Amendment to
**SPRINGS EAST AIRPORT
DEVELOPMENT PLAN**
COUNTY OF EL PASO, STATE OF COLORADO

SPRINGS EAST AIRPORT

EL PASO COUNTY, COLORADO

SPRINGS EAST AIRPORT DEVELOPMENT PLAN COUNTY OF EL PASO, STATE OF COLORADO

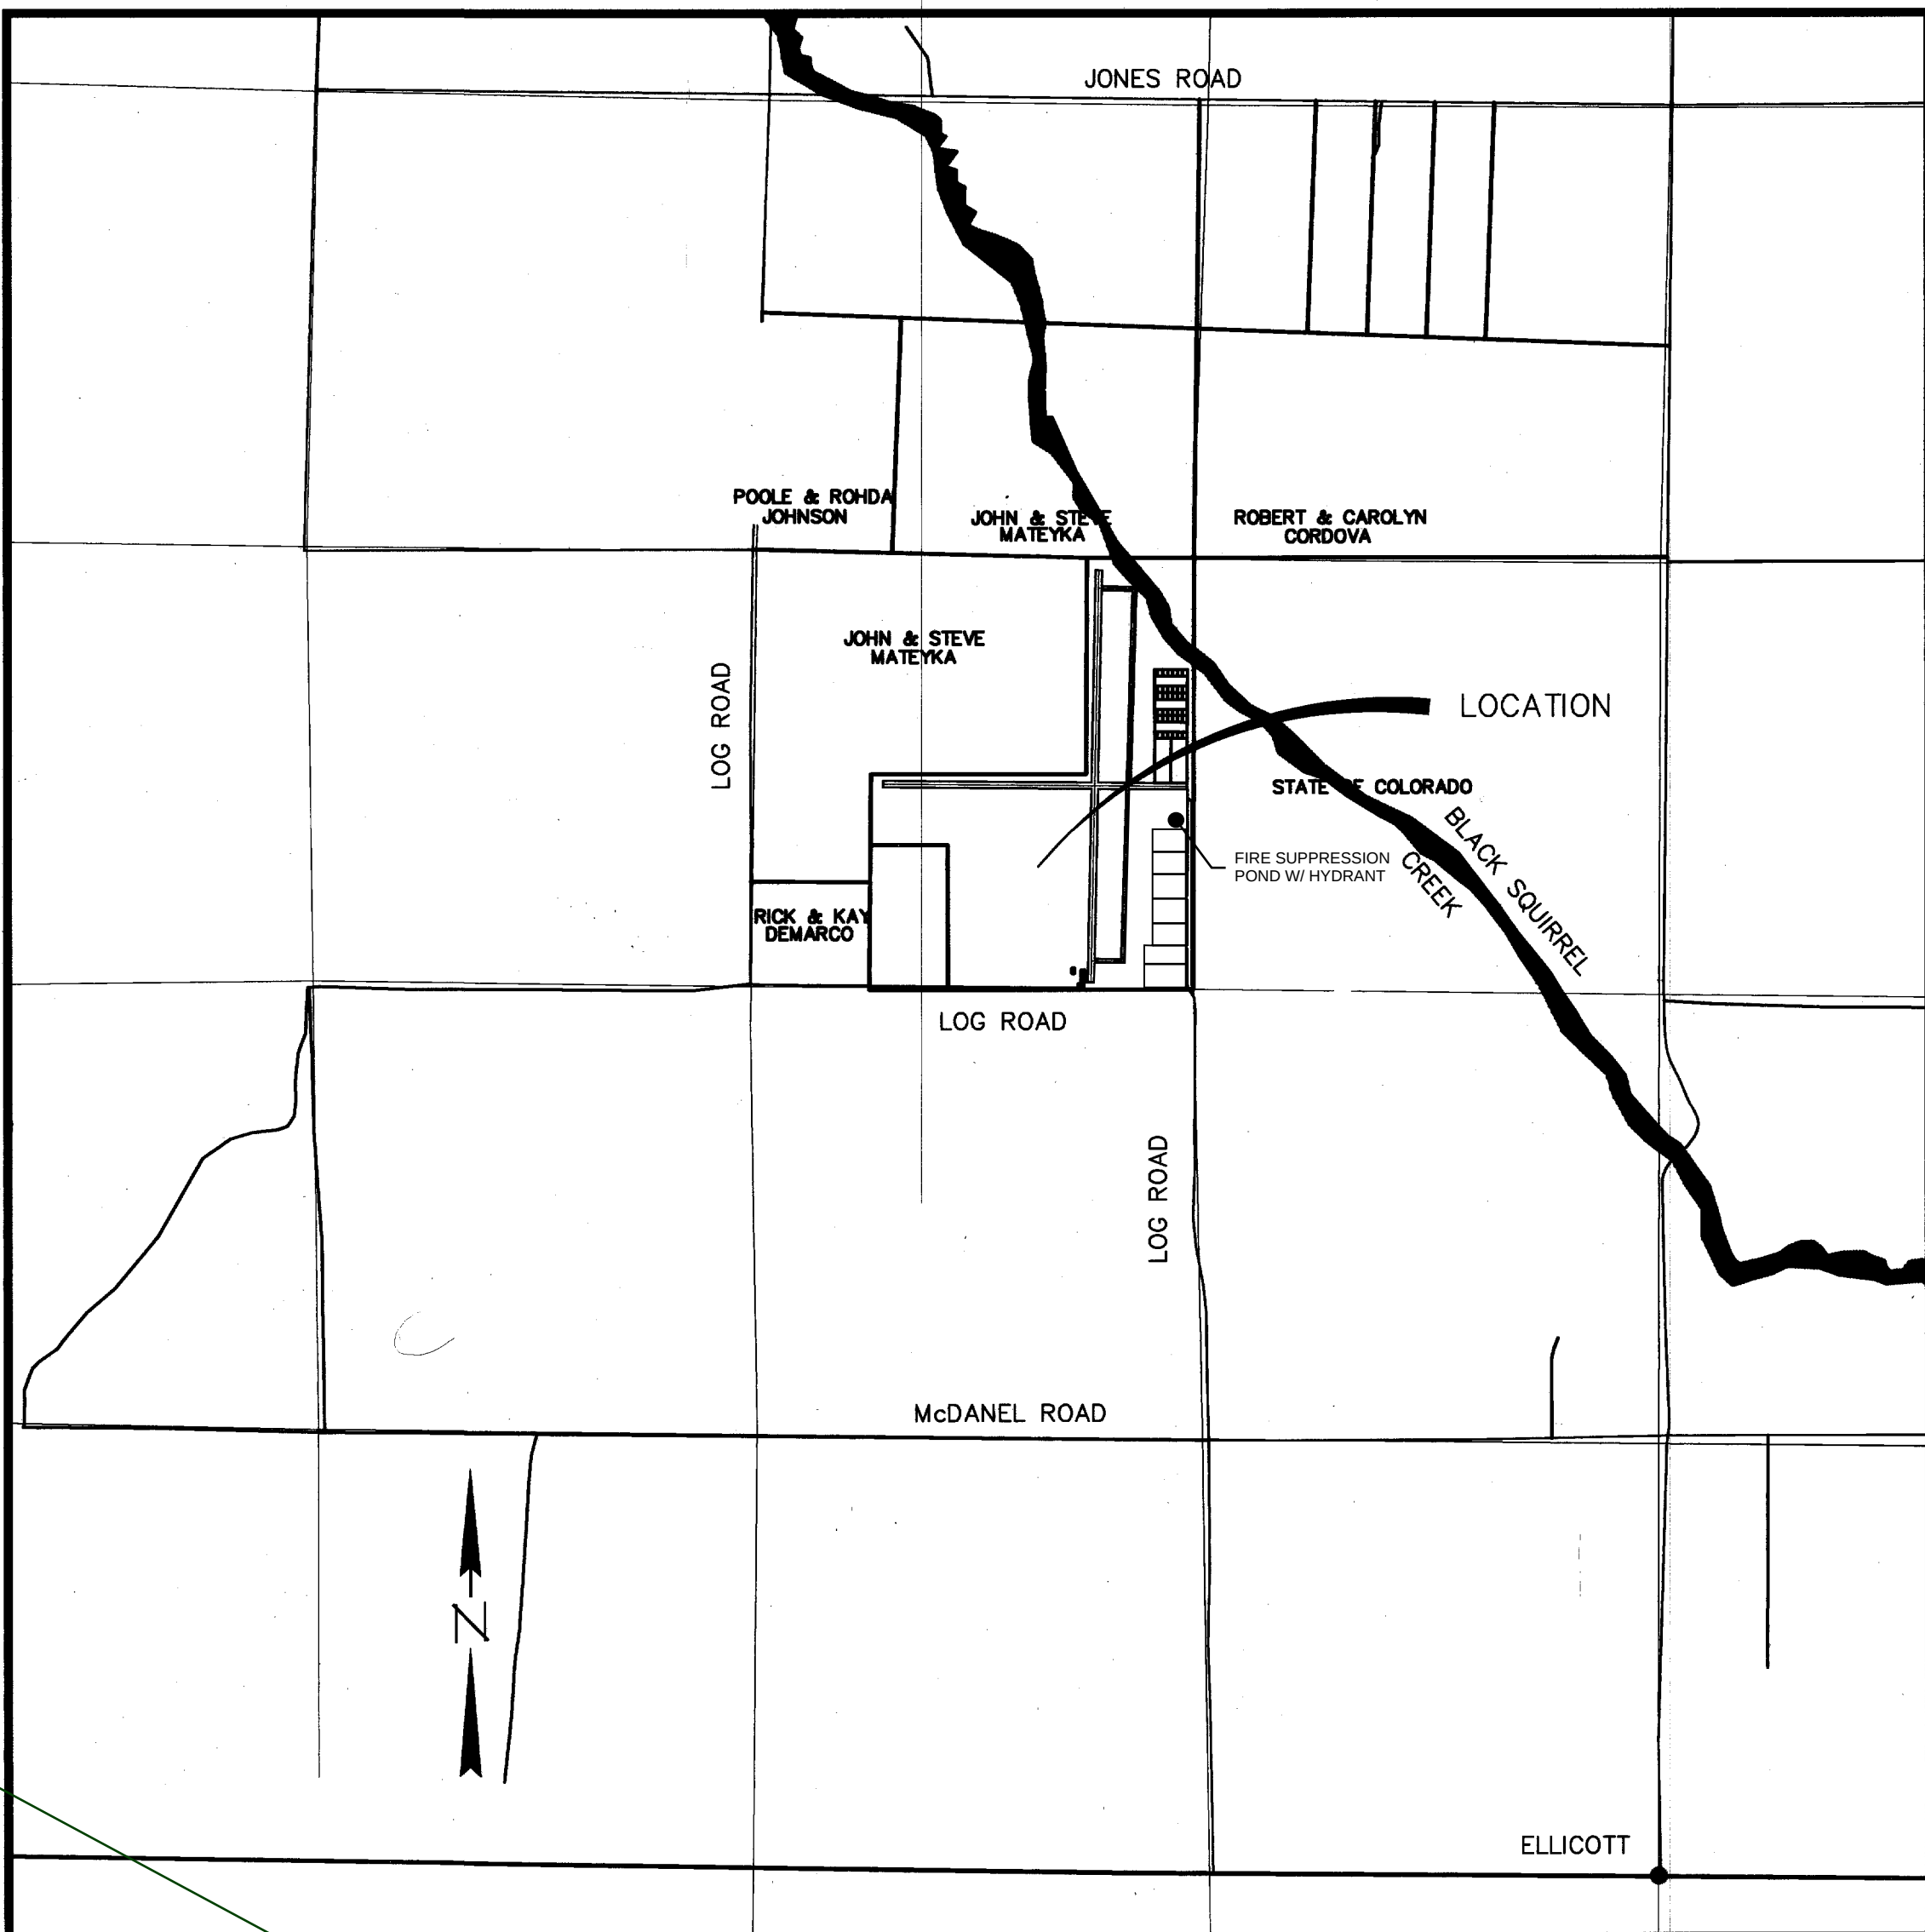
remove completely

Remove the "bubble" and place in the area being removed

Replace these signature lines with the following:

Include all 3 pages

CER This PUD Amendment for the Springs East Airport has been reviewed and found to be in accordance with Resolution # July 28, 2026 approving the amended PUD and all applicable El Paso County Regulations.

CER Planning and Community Development Director Date
